Claremont Business Park (Tract C, Filing 2)  
Transportation Memorandum  
(LSC #195040)  
November 26, 2019

Add PCD File No. SP197

RE: Claremont Business Park (Tract C, Filing 2)  
El Paso County, Colorado  
Transportation Memorandum  
LSC #195040

# CLAREMONT BUSINESS PARK PRELIMINARY PLAN

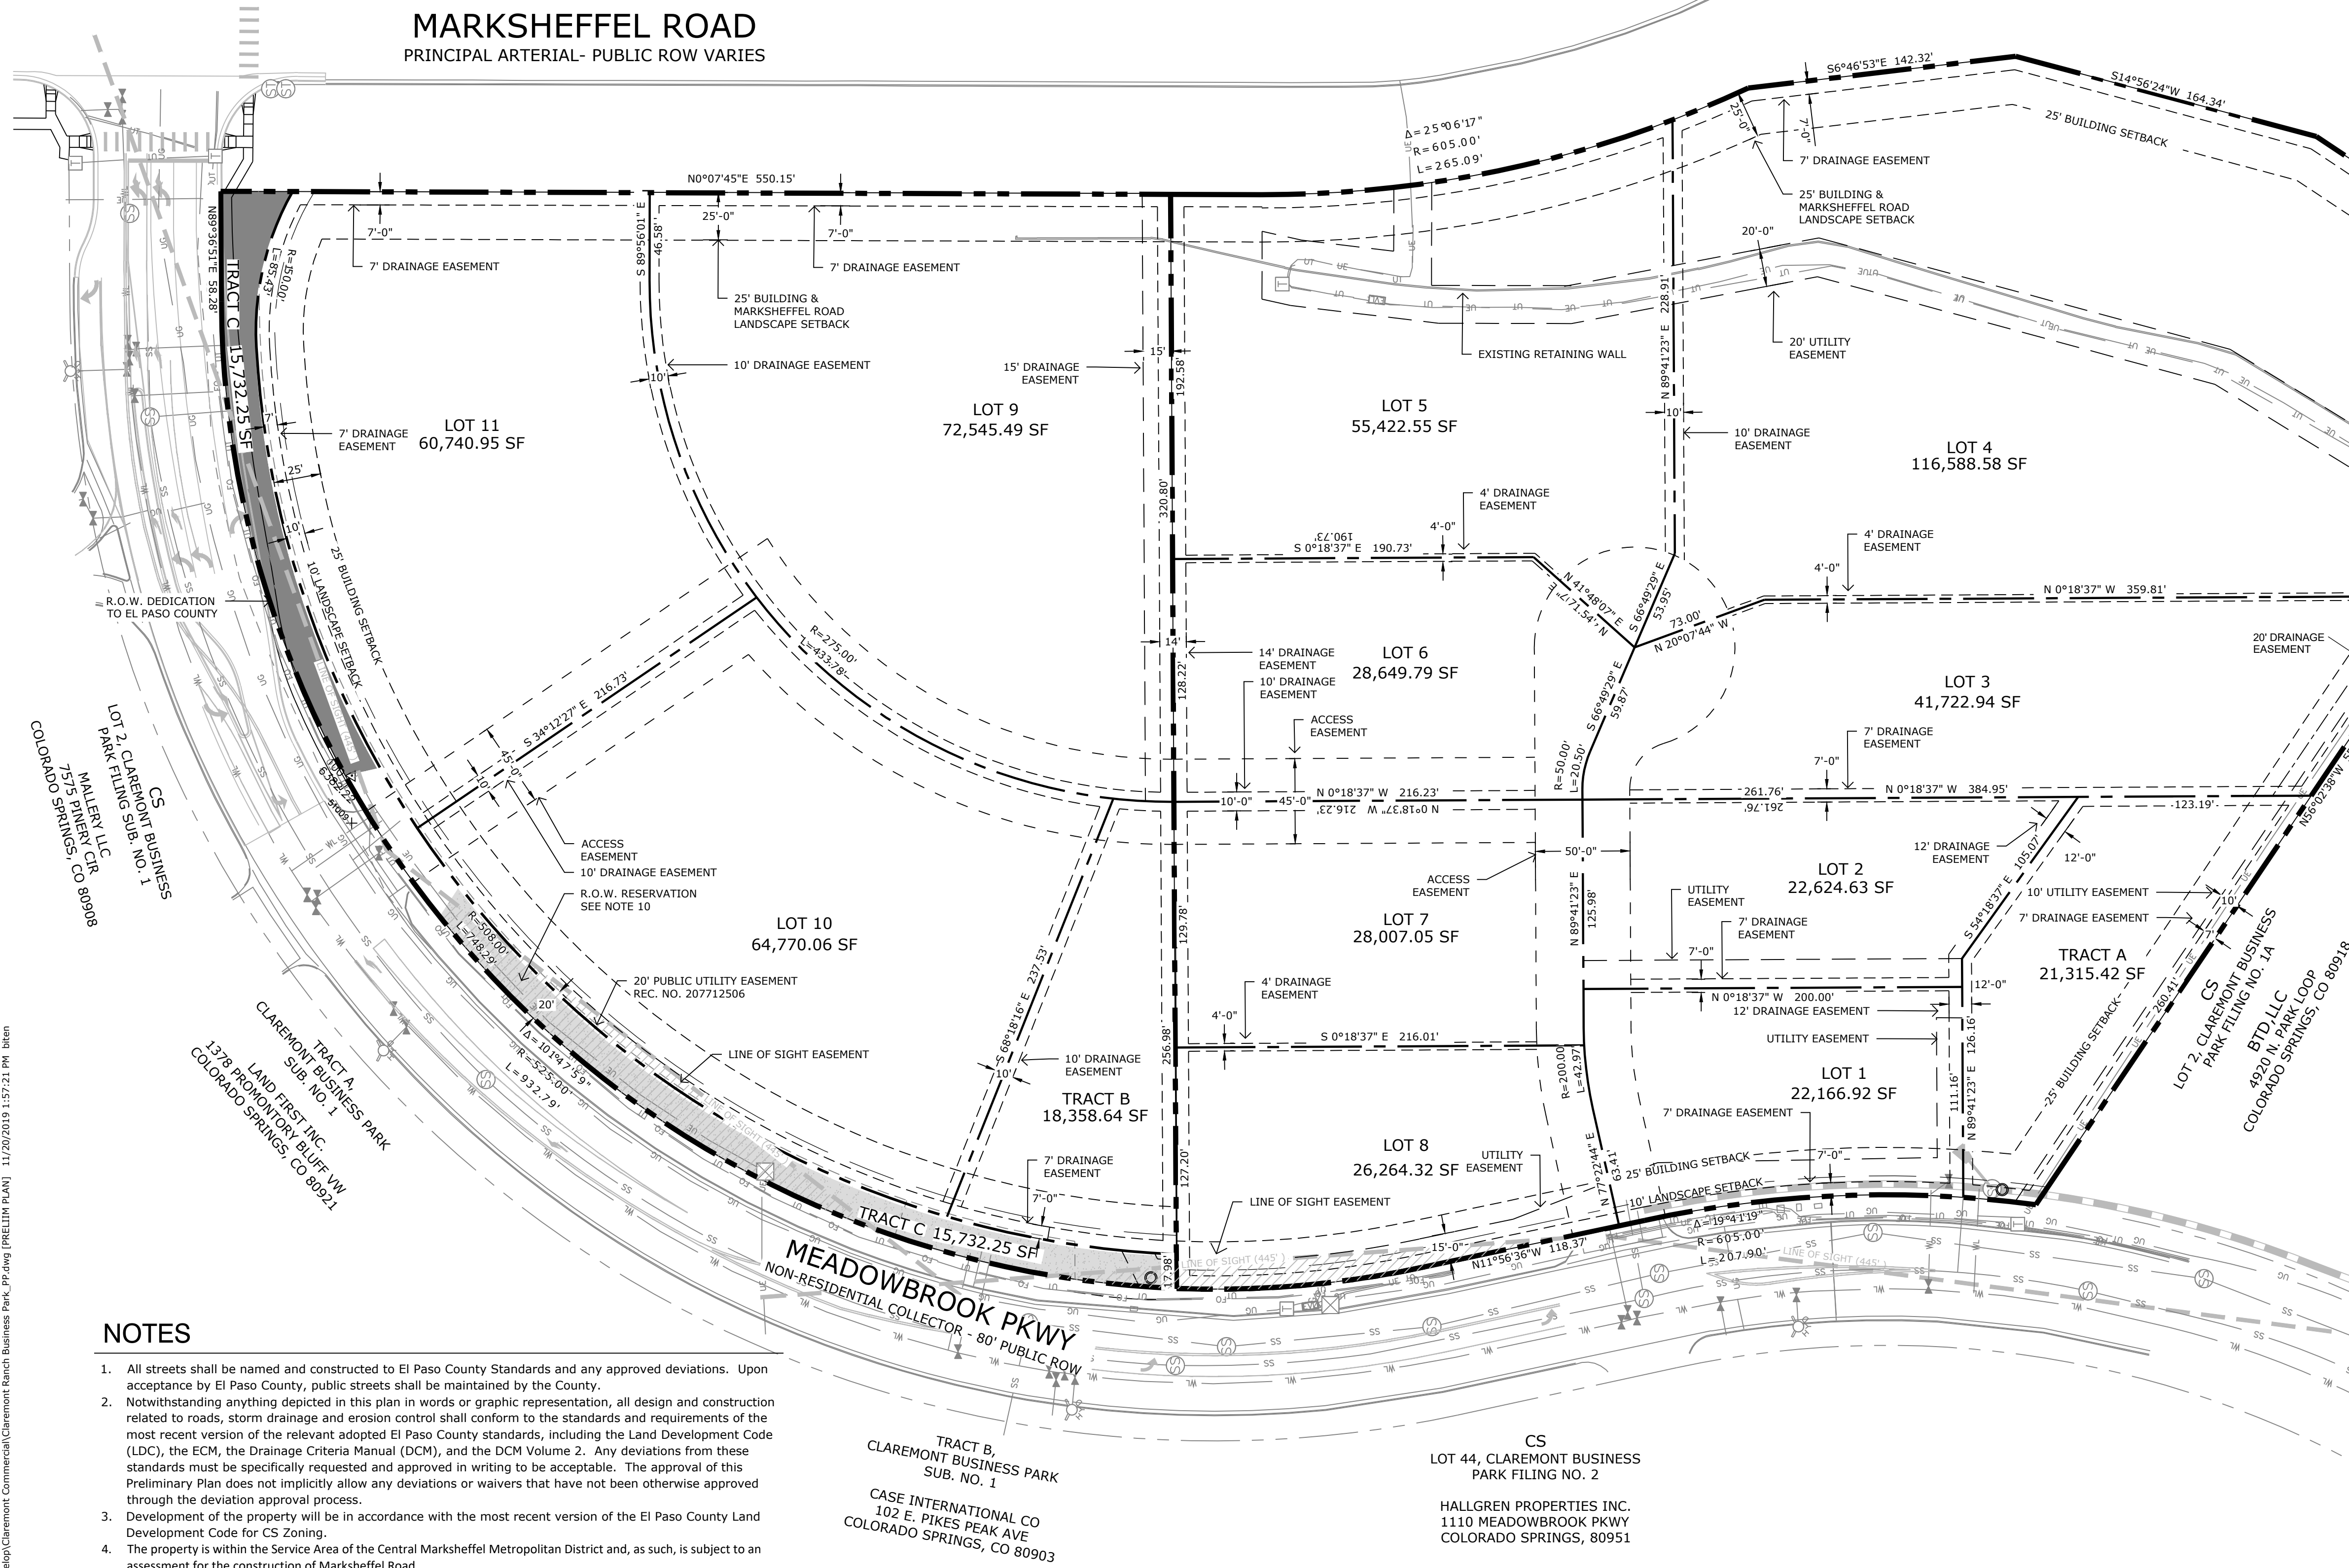
There are two points of access shown on the preliminary plan. Please revise.

There is a second access shown on the preliminary plan. Include discussion regarding the 2nd access and indicate whether these access points meet County criteria.

Please analyze the 2nd access point. Indicate the County criteria for the two access points and whether they meet it.

ROW reservation has not been provided. An access easement is shown on the preliminary plan that extends to the 2nd access point. Please revise this paragraph accordingly per the proposed preliminary plan that has been submitted.

Please update the narrative accordingly as the site will have two access points. Update the distribution analysis accordingly (make sure to account for the signal that was recently installed.)
